**Subject:** RE: Application reference 23/00473/F - Scott, Baytree Cottage, West Rudham

Attached are drawings showing existing and proposed alteration to the garage/carport to create the annexe as described in the application.

BAY TREE COTTAGE CONVERSION PLANNING ELEVATION VIEWS_ SCALE 1:50

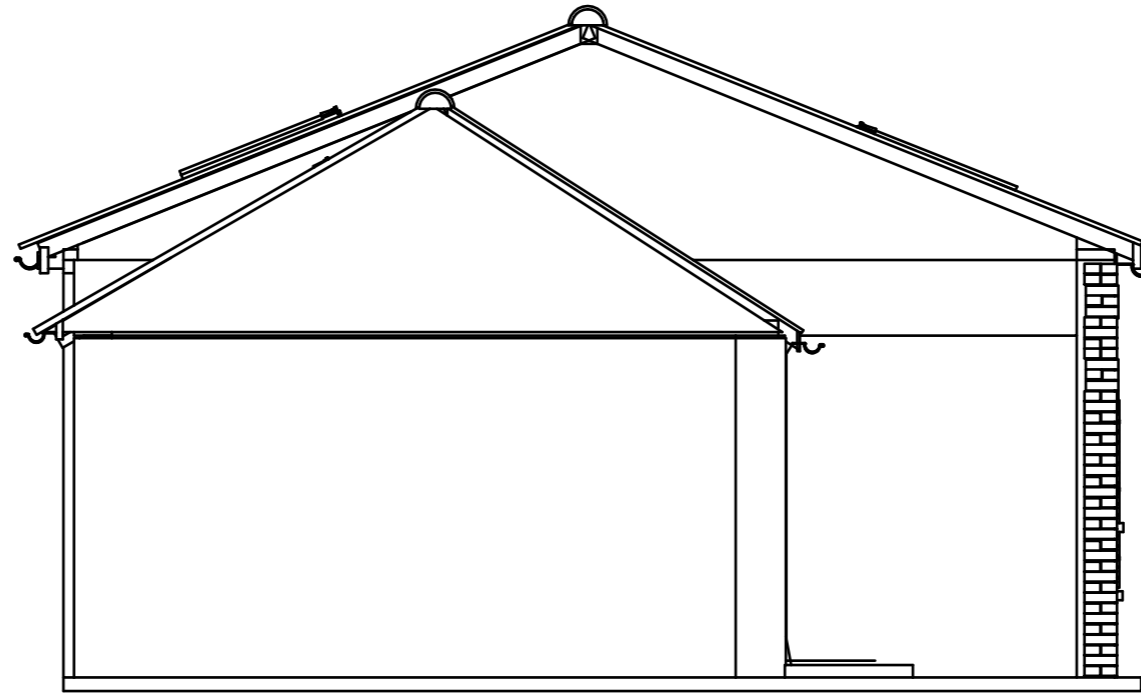
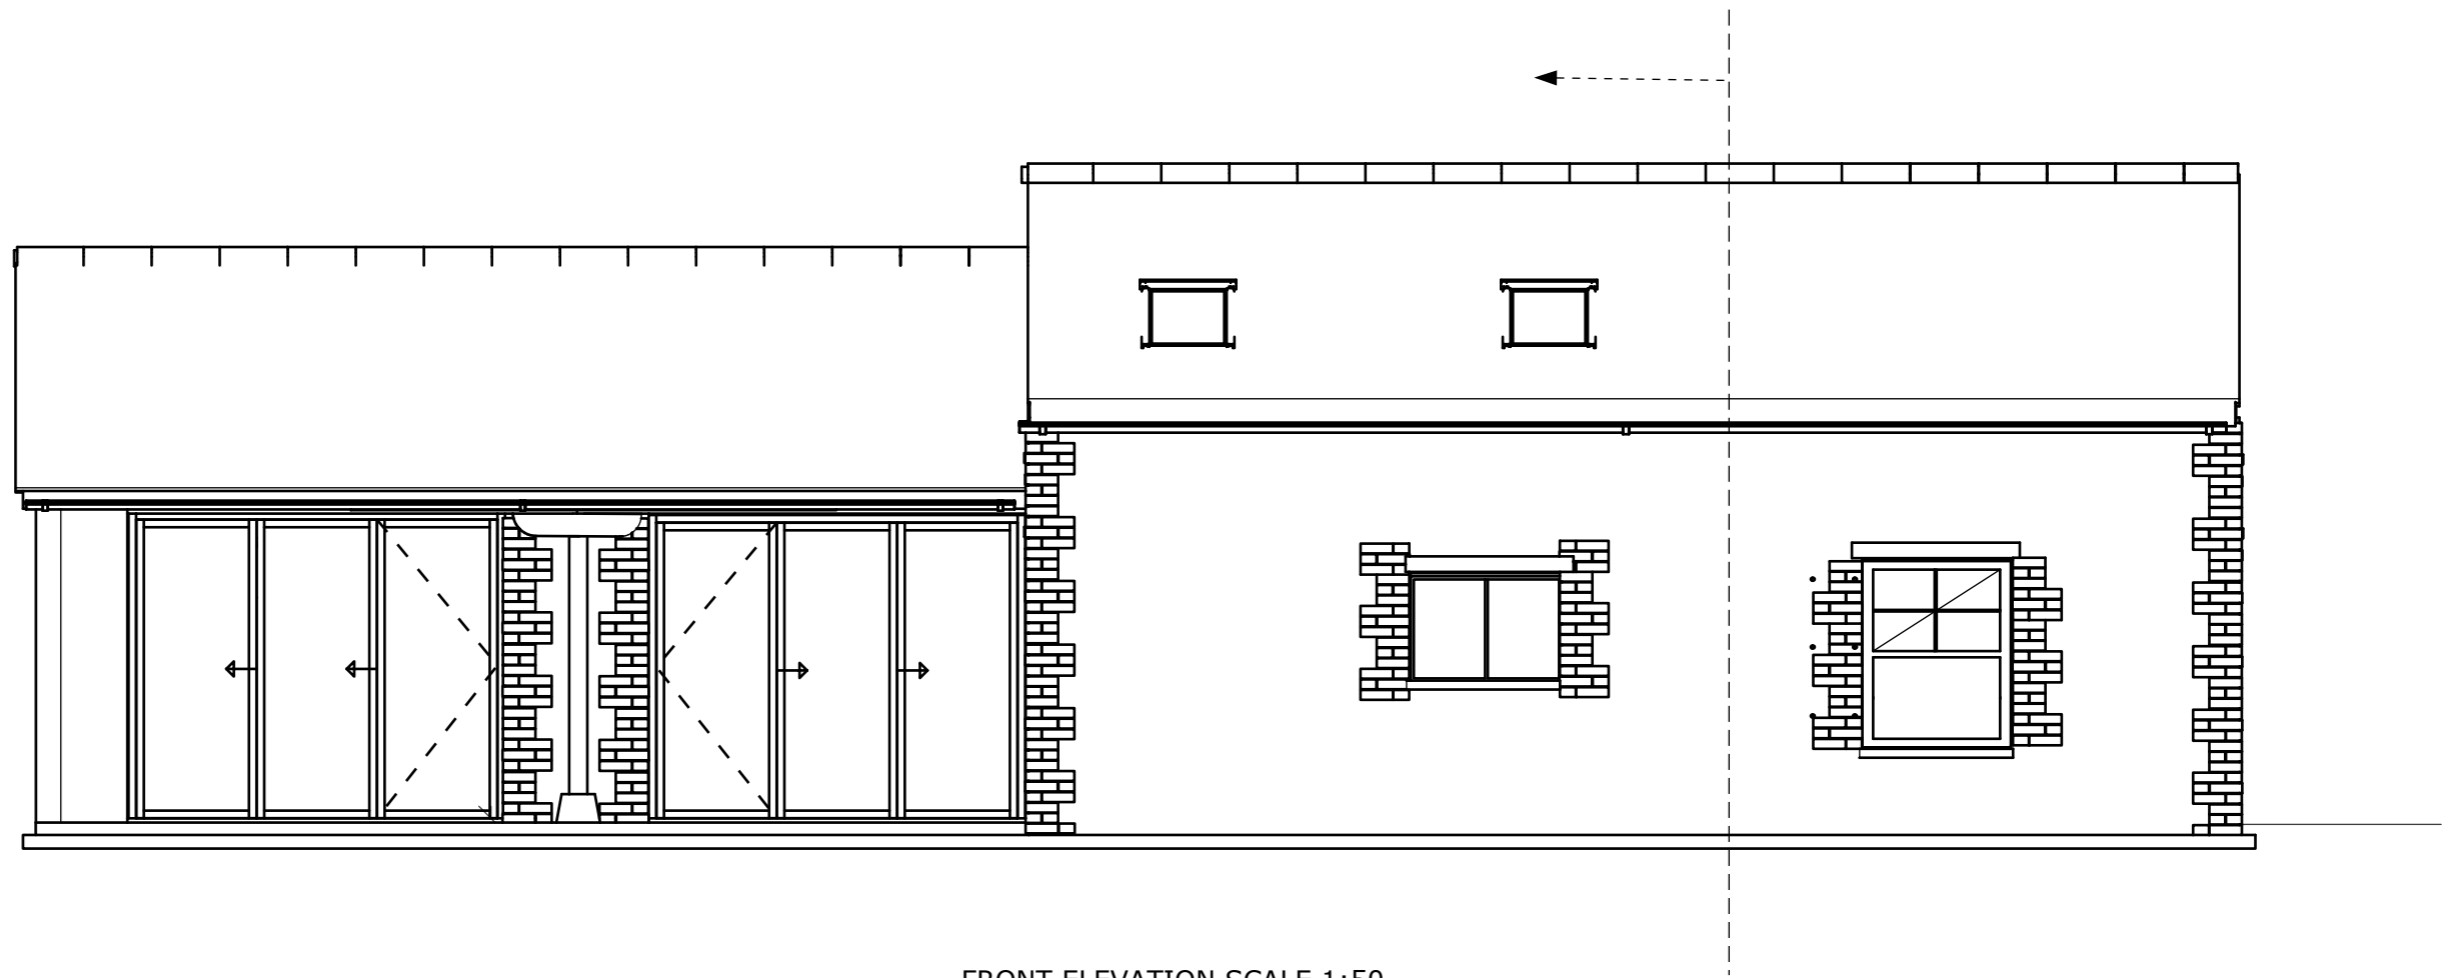
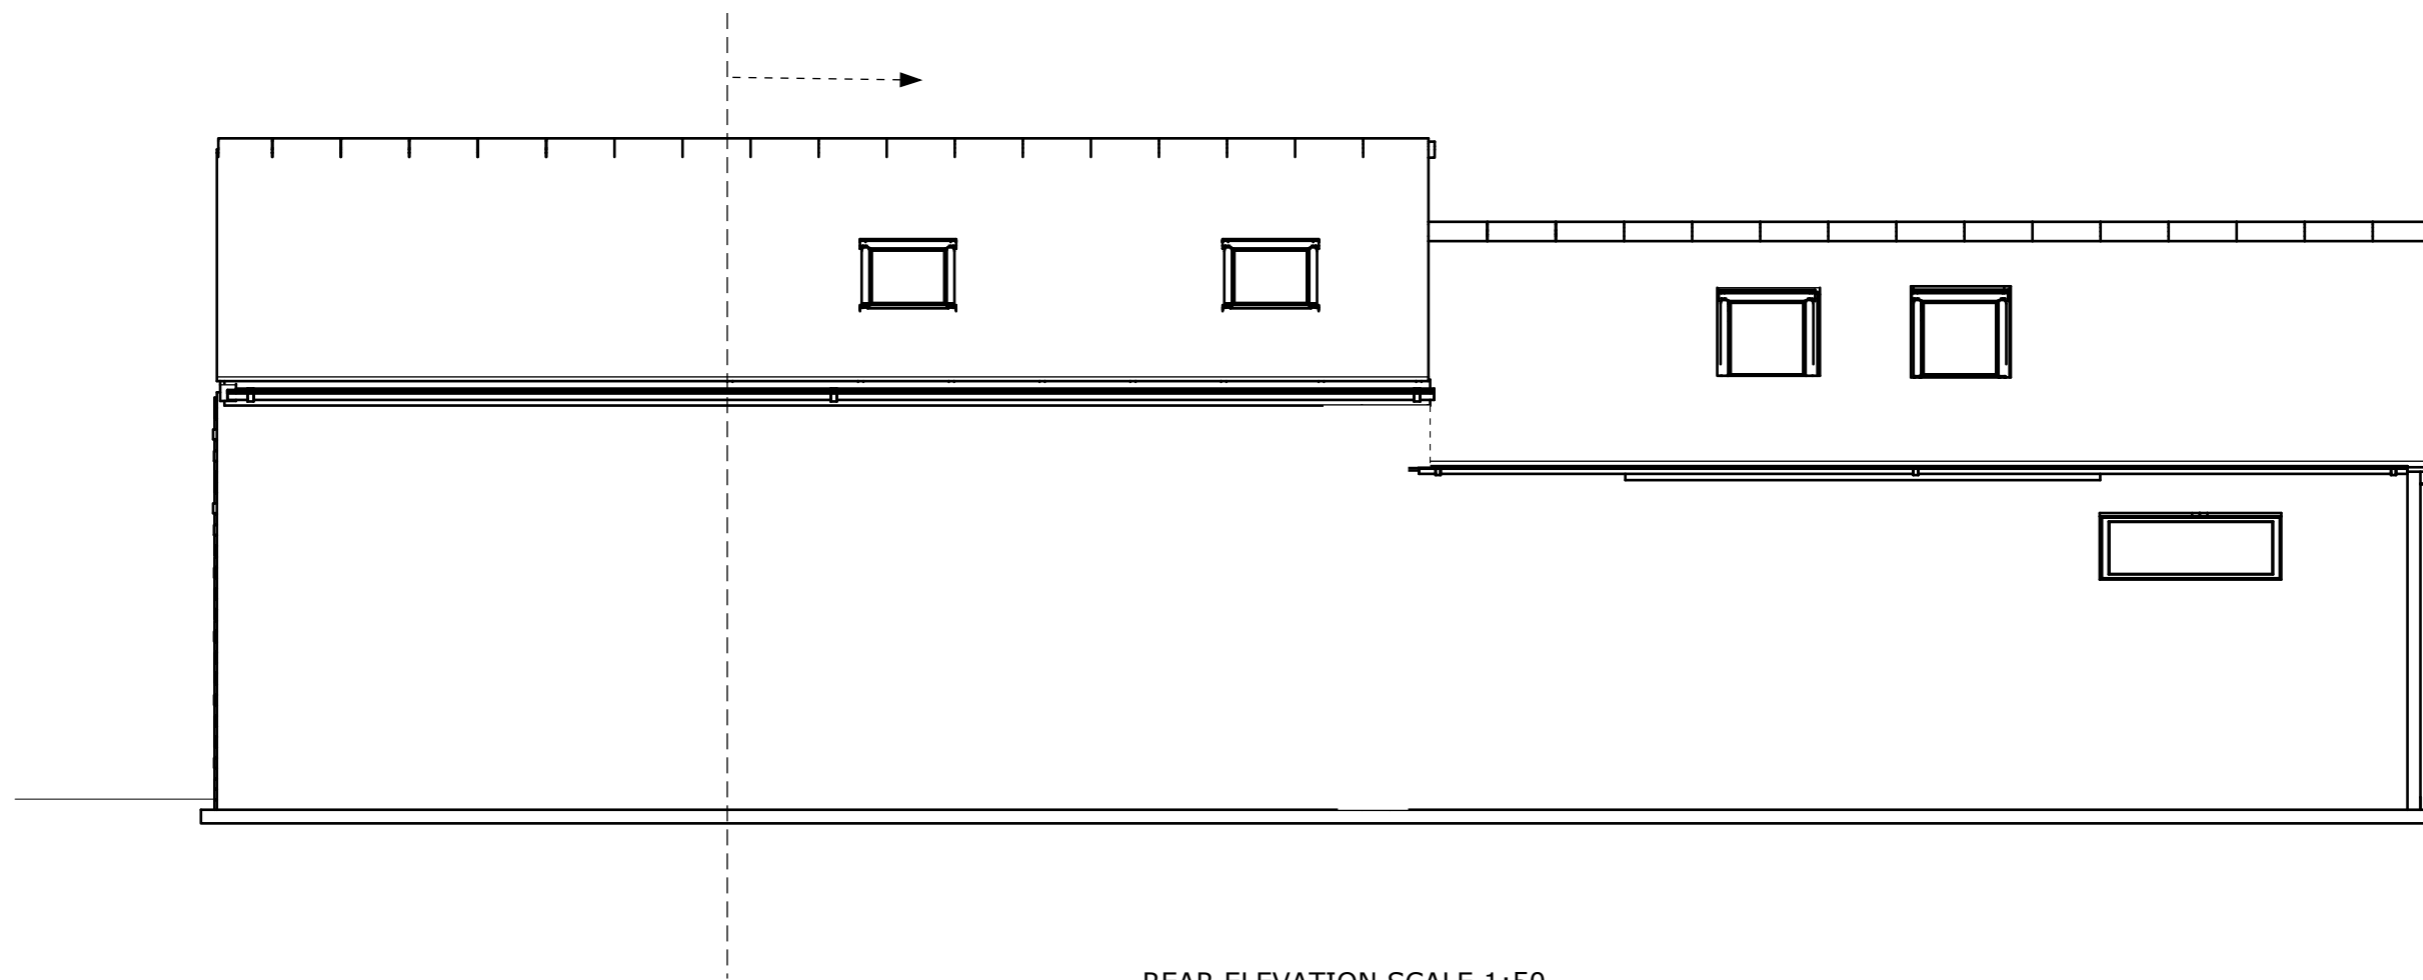
Thank you for your email with the proposed Plans it appears that the roof lights showing on the elevations are not measuring the same on the floor plan please amend and resubmit , Please could you provide existing floor plans and elevation to a scale of 1:50 or 1:100, and an existing and proposed site plan to a scale of 1:200 or 1:500 .

Please find amended drawing showing floorplan with location of the skylight in relation to proposed floorplan.

PLAN VIEW SCALE 1:50

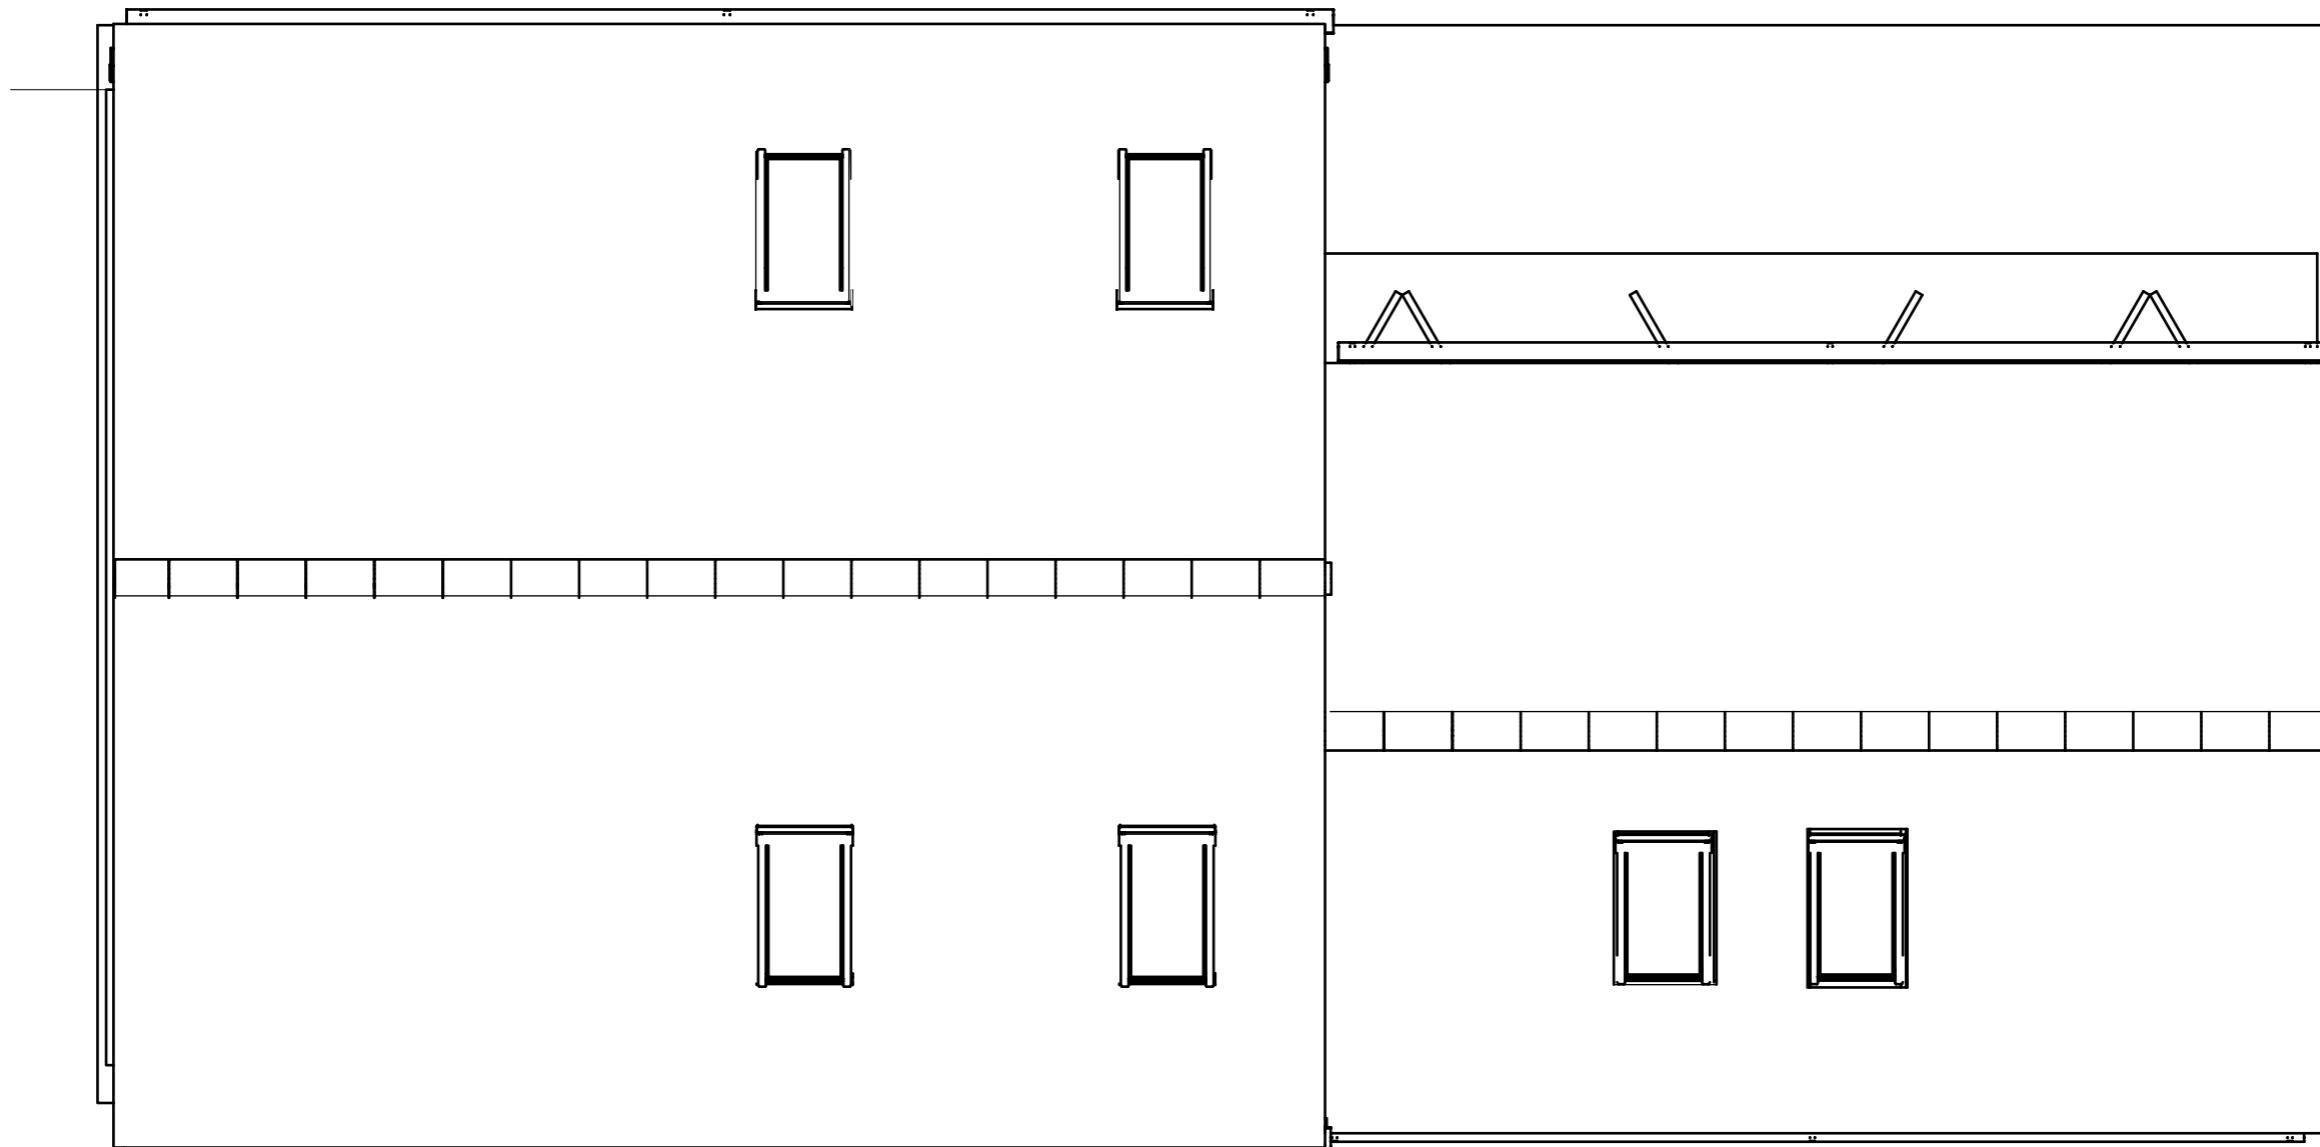
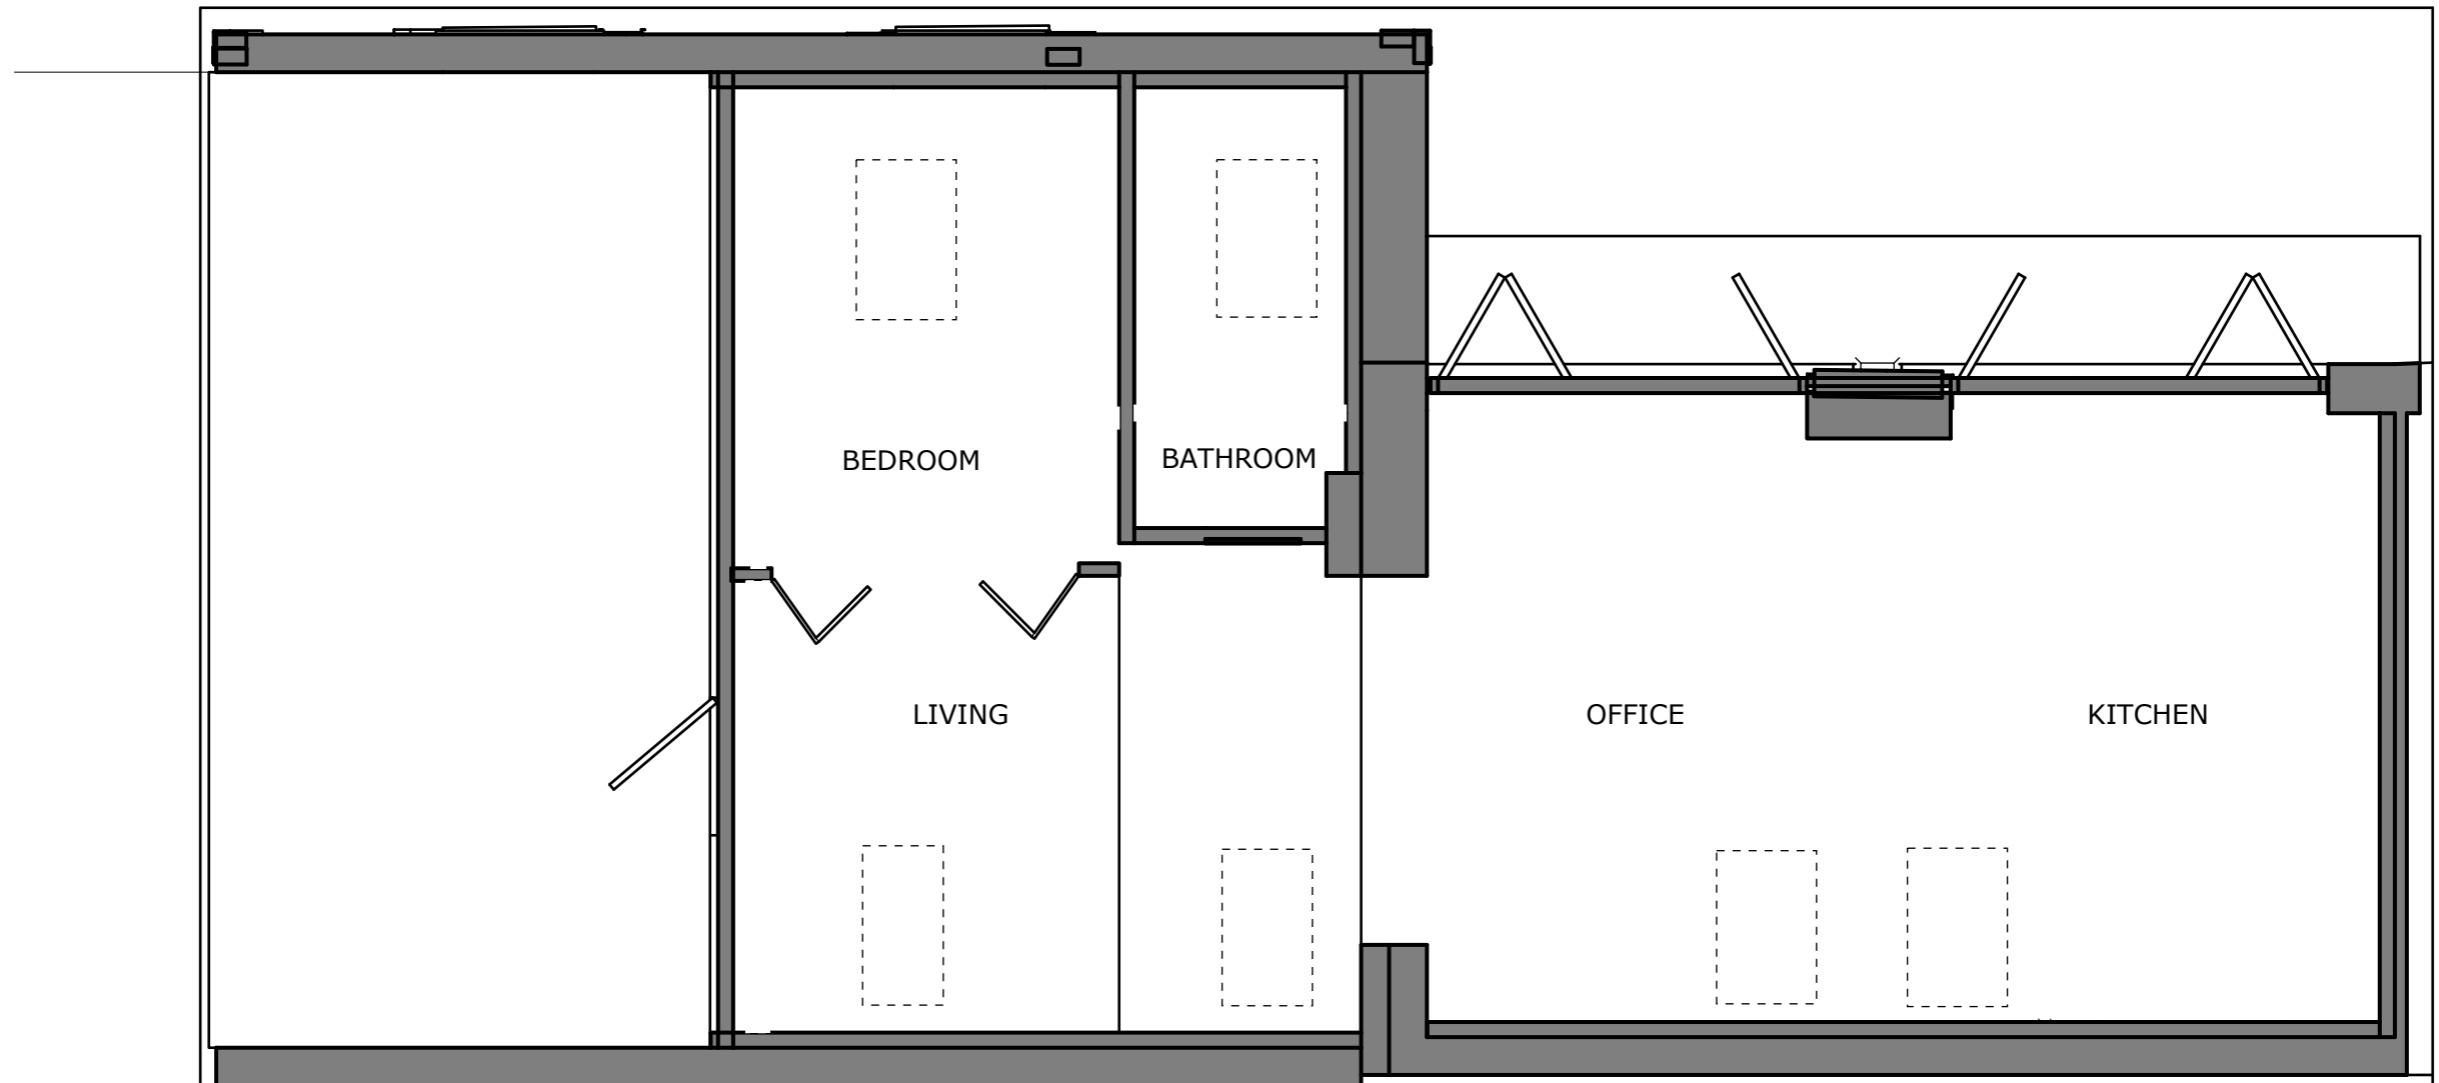
This plan doesn't appear to be to scale, at 1:50 the length of the building on your plan is measuring 3.8m and the width measures 1.8m. Please submit the plan so that it is to scale, please also show all openings and the roof lights on the floor plan.
